From: [Tyler Kretschman](#)
To: [Zach Torrance-Smith](#)
Subject: Mastec Communications (ACU-25-00001)
Date: Thursday, March 13, 2025 8:35:08 AM
Attachments: [image001.png](#)
[image002.png](#)

My wife and I received a letter in the mail that Level 3 Communications was going to be building an additional 23'x36' communications shelter next to our house, parcel 14907 – 4080 Lower Peoh Point Road, Cle Elum, Wa.

A2.1

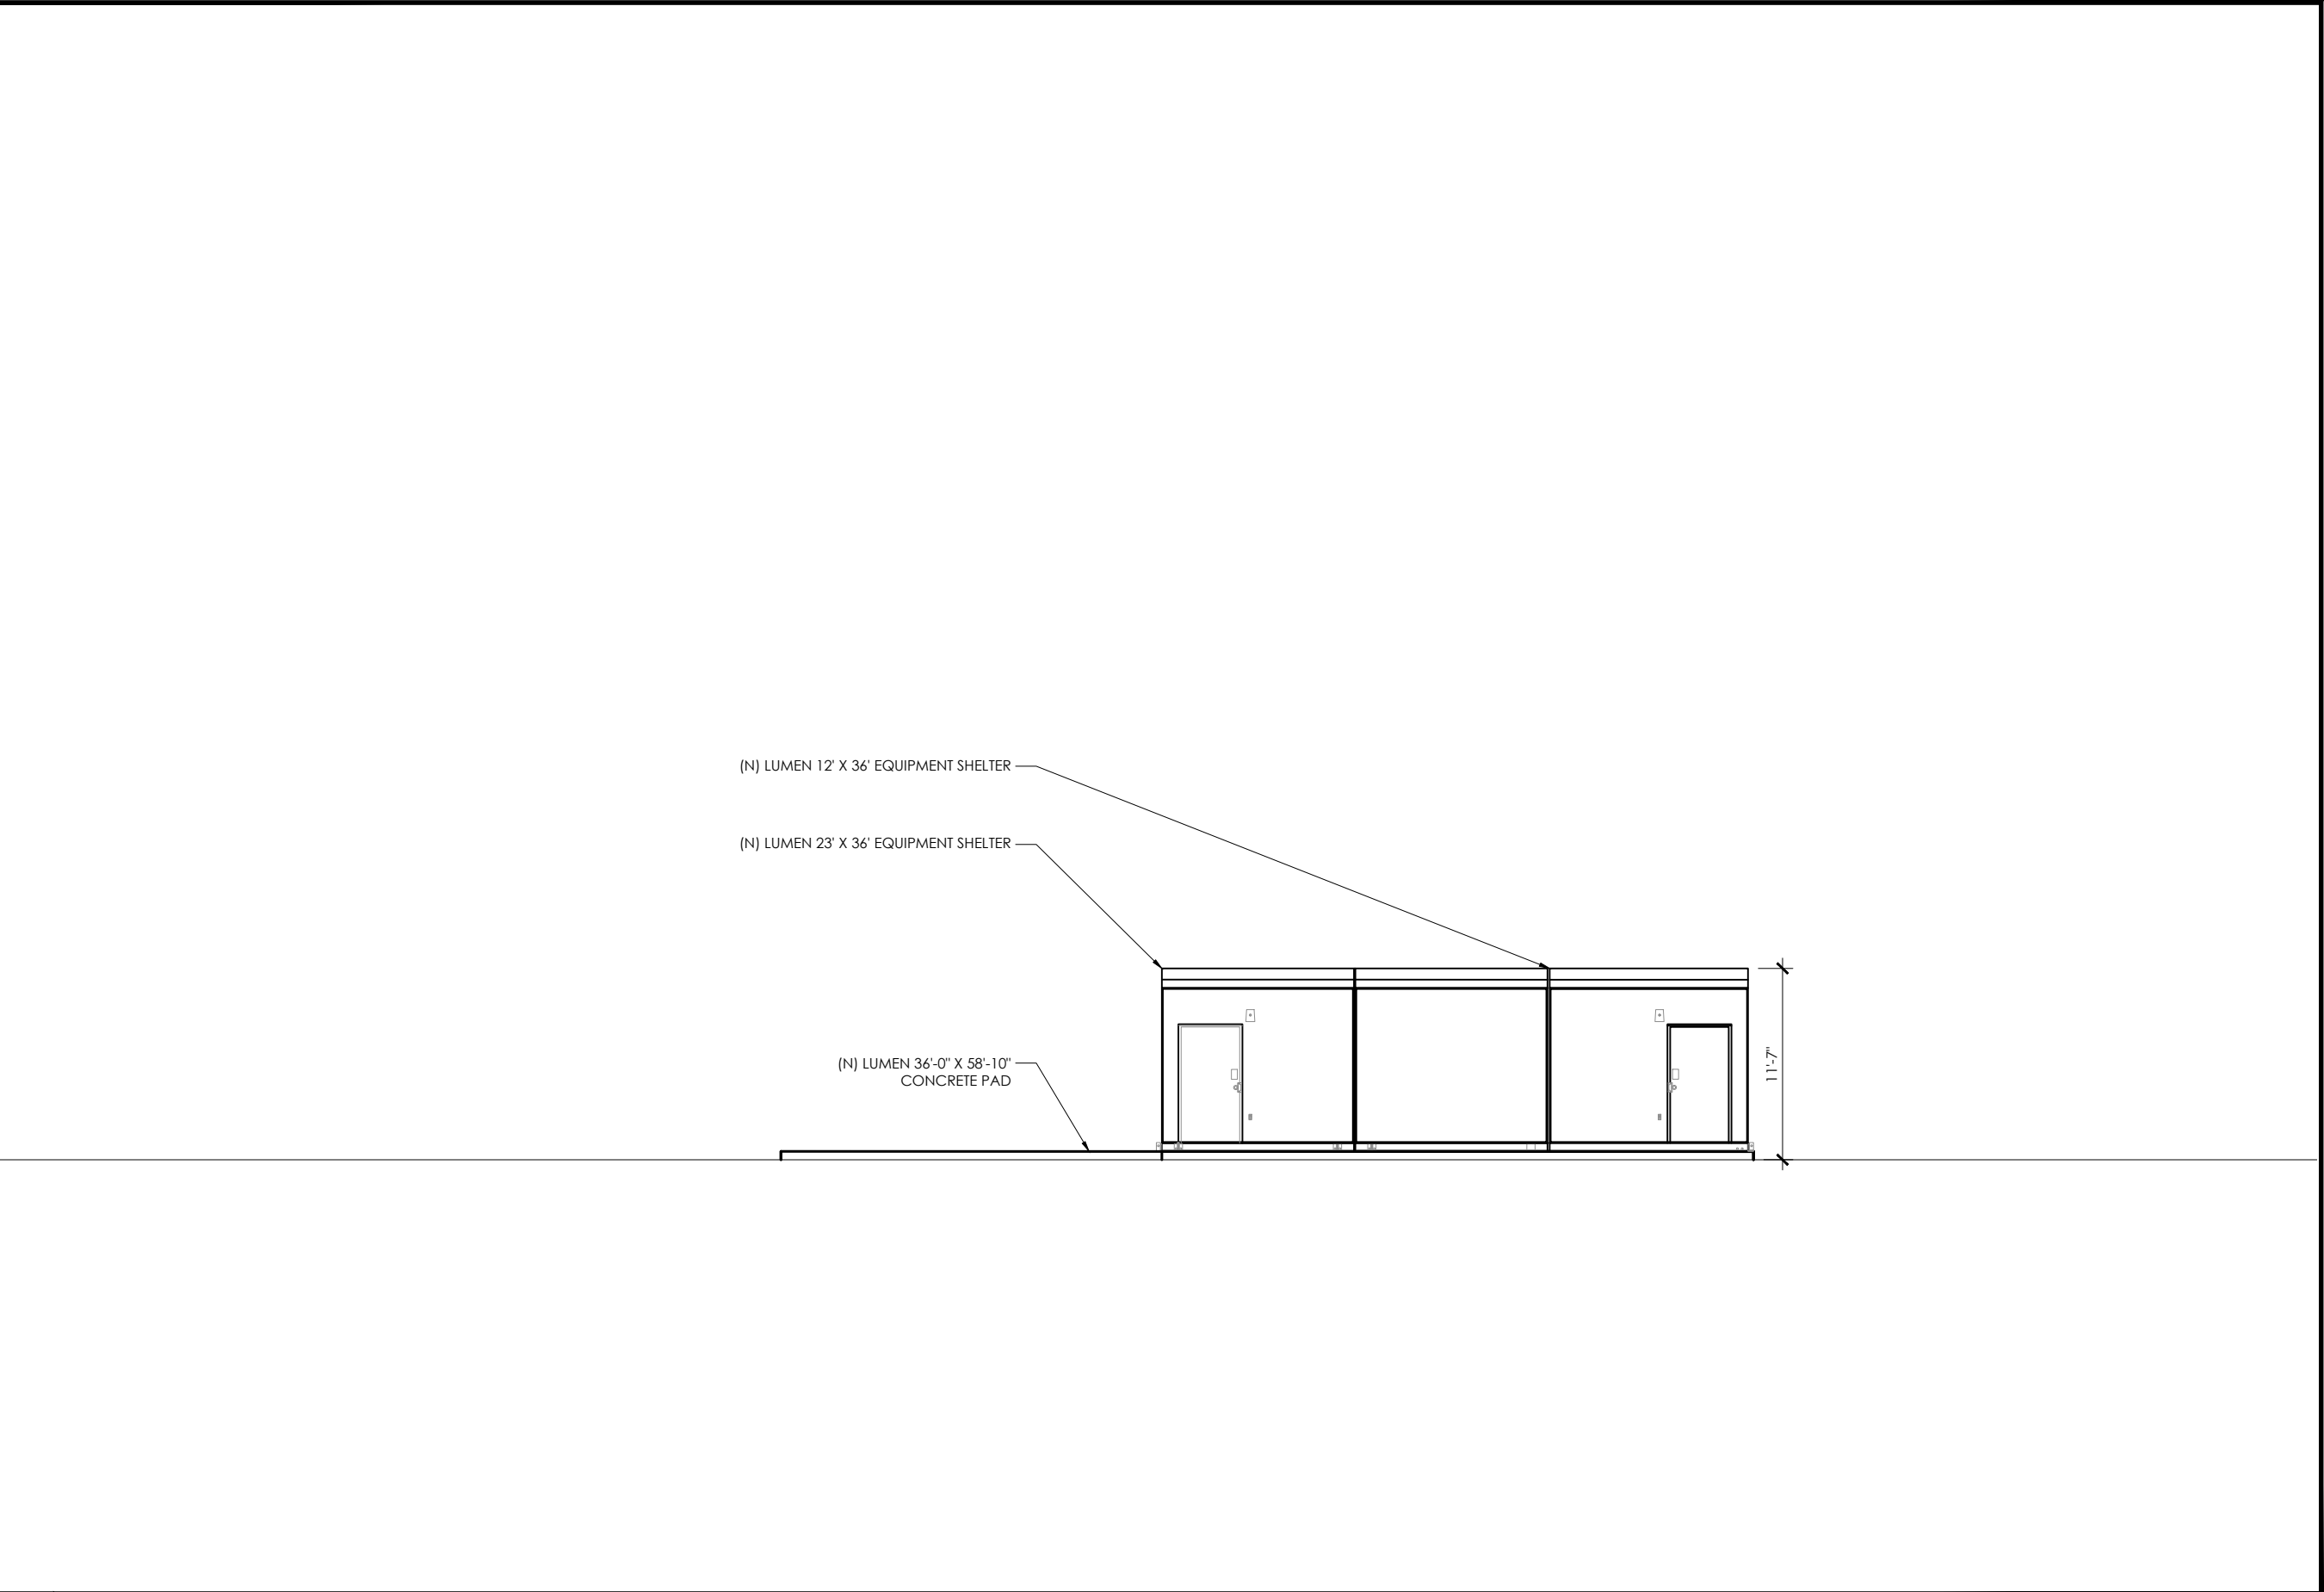
1. Does Level 3 communications have any purposed landscaping to be installed around the shelters? It was told to us by Cliff Winfrey & Shelley Winfrey, former owners of the Alloway short plat, that landscaping would be provided around the existing communications shelter onsite.
 - a. To date, there has been no landscaping completed around the existing structure.
 - b. Will the new structure and current structure receive any landscaping?
2. The existing shelter when it kicks on, generates noise, will they both run concurrently?
Curious because that will generate an obnoxious amount of noise.

My only request as a homeowner trying to protect my property value would be to have Level 3 communications plant Hybrid Willows down the property line from Lower Peoh to the furthest south communications structure for noise and eye sore mitigation.
